Application no: H15-0321-10

Description: Erection of 12 affordable dwellings and associated works

Location: Land off St Margarets
Quadrant
Spalding
Lincs
PE11 4PS
PE11 4PS

Amendment: Addition of field access (dwg. no. PL01.A)

A		06/05/10		FIELD ACCESS AND INFORMAL P.O.S. ADDED	
rev	date	Copyright reserved	Do not scale	All dimensions to be checked on site	
Project		ST MARGARET'S QUADRANG			
Drawing		Proposed Site Layout			
Date		Scale	Job No	Dim No	Rev
07/04/10		1:500 @ A2	Quadrang	PL01	A

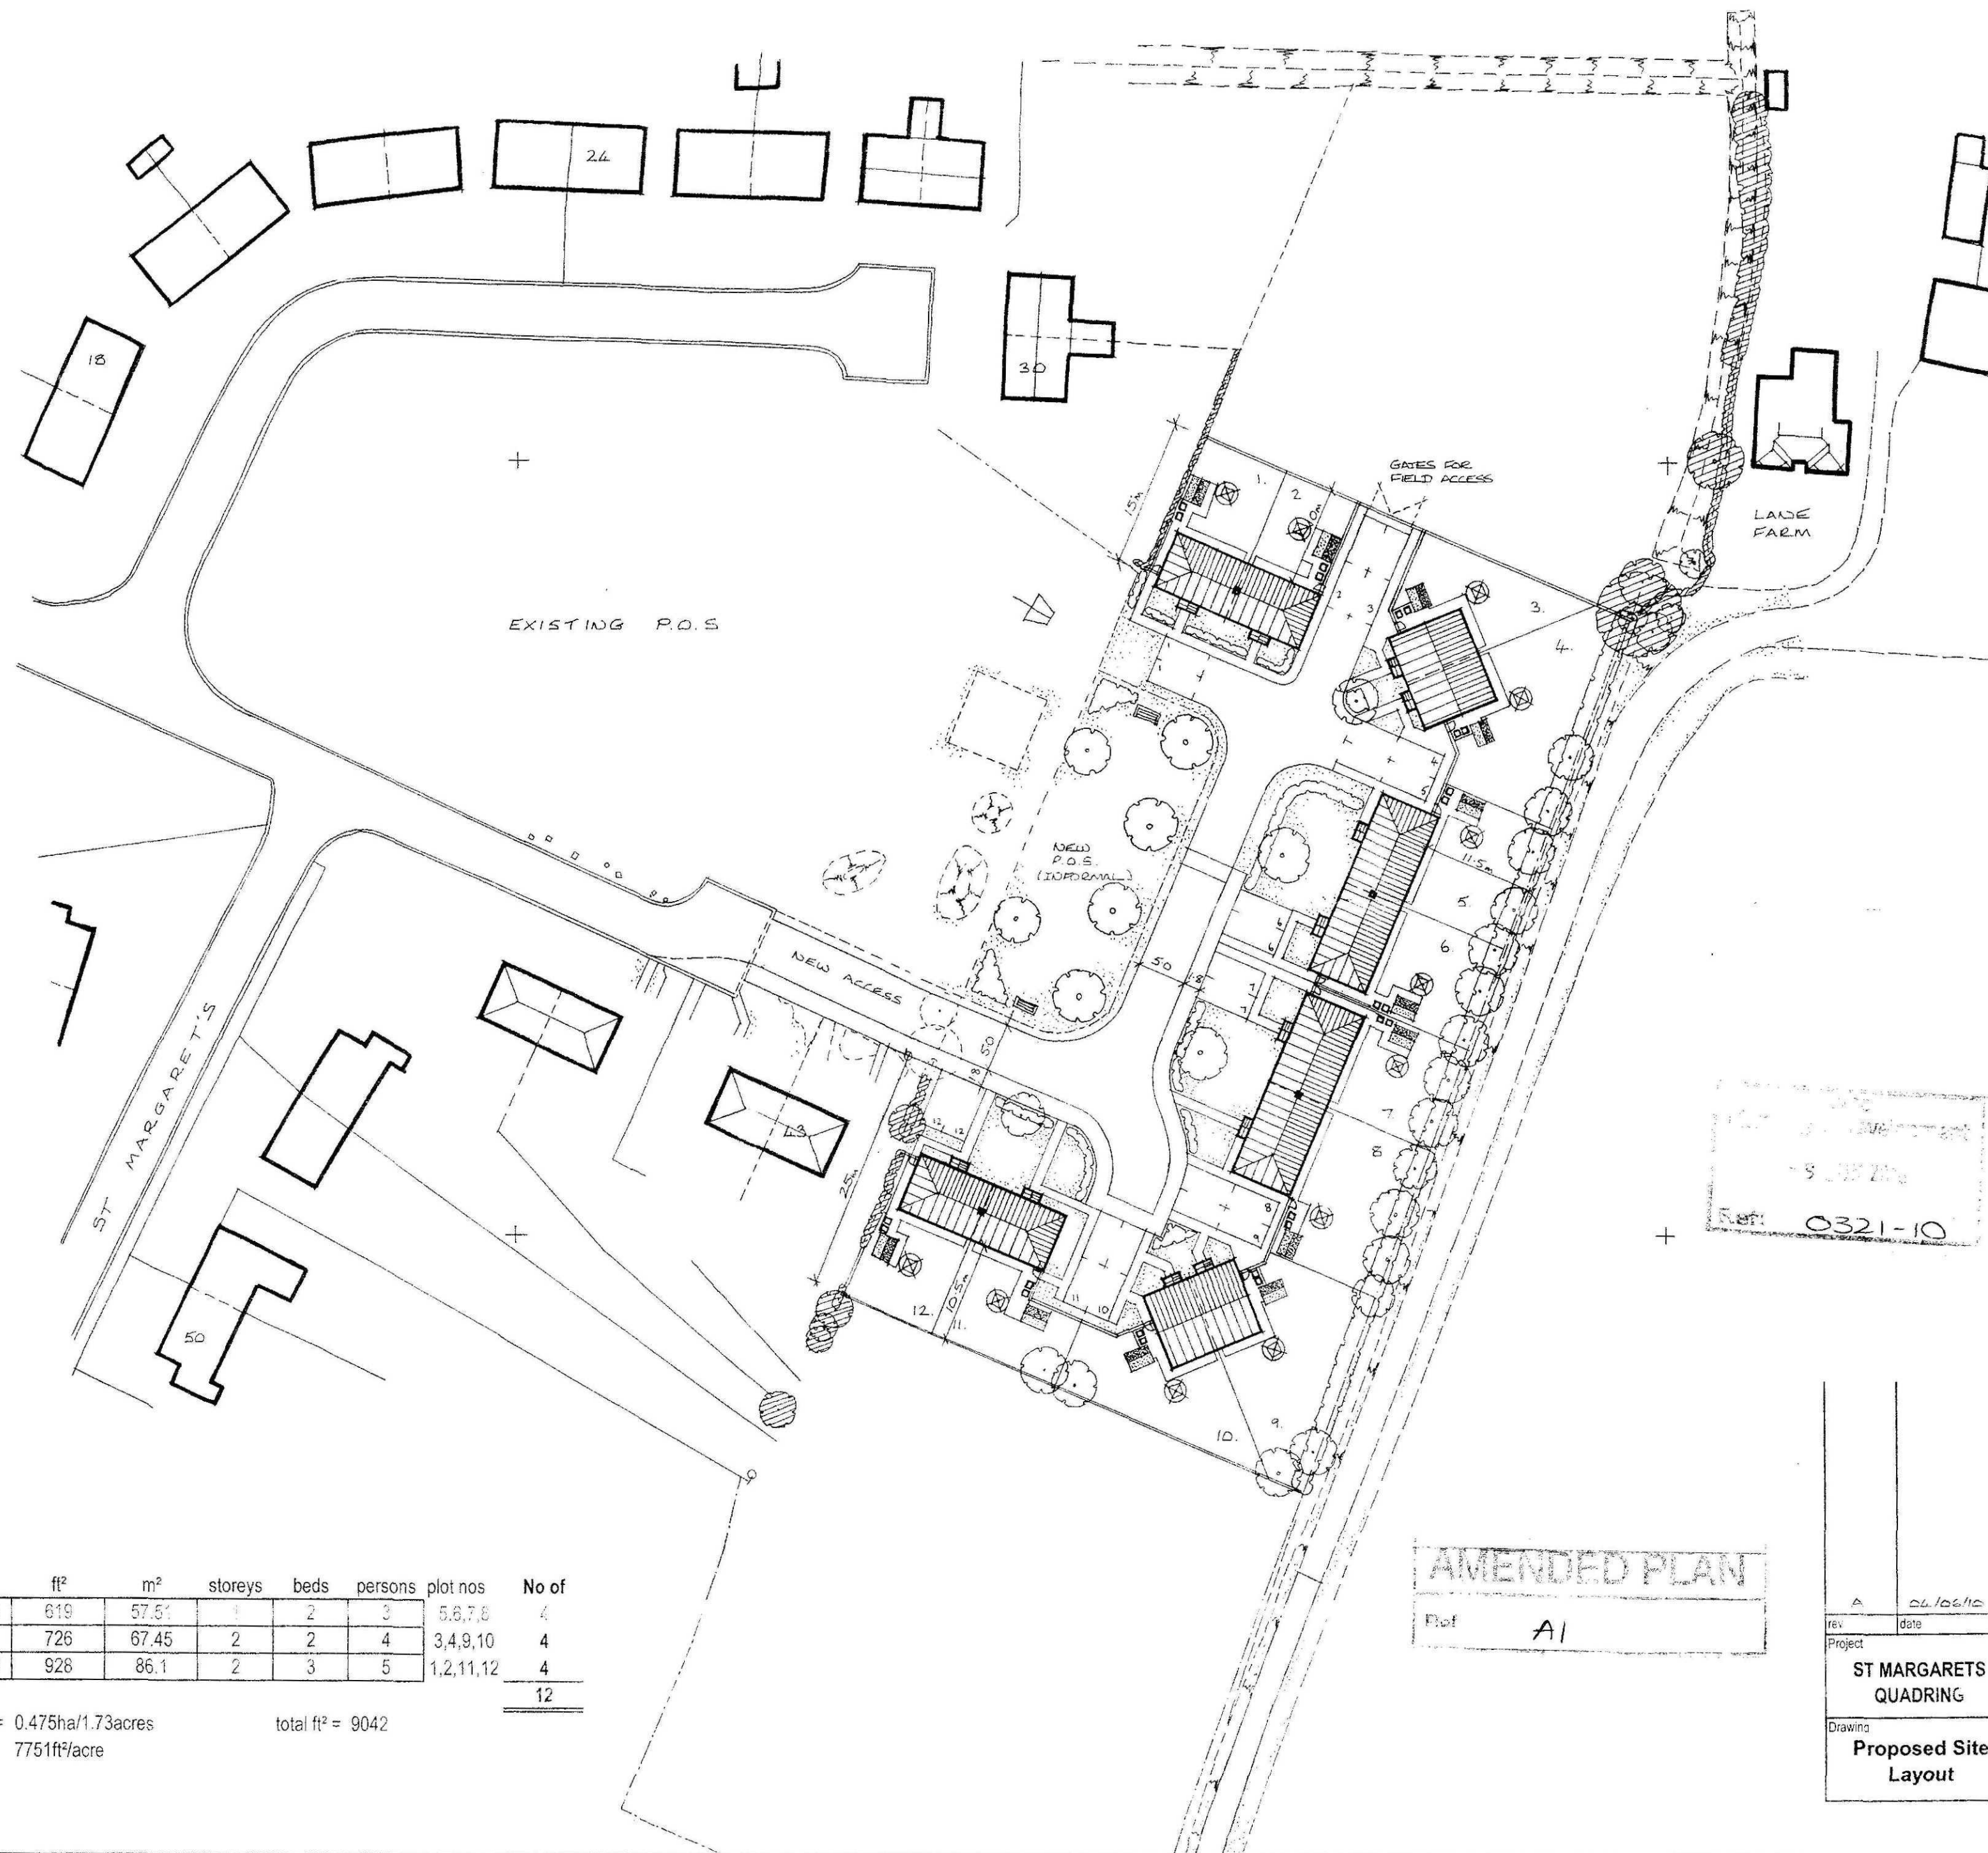
You may also want to visit our website to read the representations received. Note Highways comments regarding parking of vehicles at the end of the road and the request to provide space for existing residents to park.

A number of local residents and the Parish Council have also asked questions in particular about the remaining areas of the field to the north and south of the application site.

- 2) Concerns have also been raised over the future use of the land to the north. At this stage the use is unknown and will remain in agricultural use. We have amended the site layout plan to show the provision of a gated access to this land so that it can be maintained in the future should the development proceed.

- 3) Parish Council Comments:
 - a) We do not intend to remove the existing fence
 - b) The newly formed area of POS will be laid as informal open space (see plan) and will be managed by the RSL
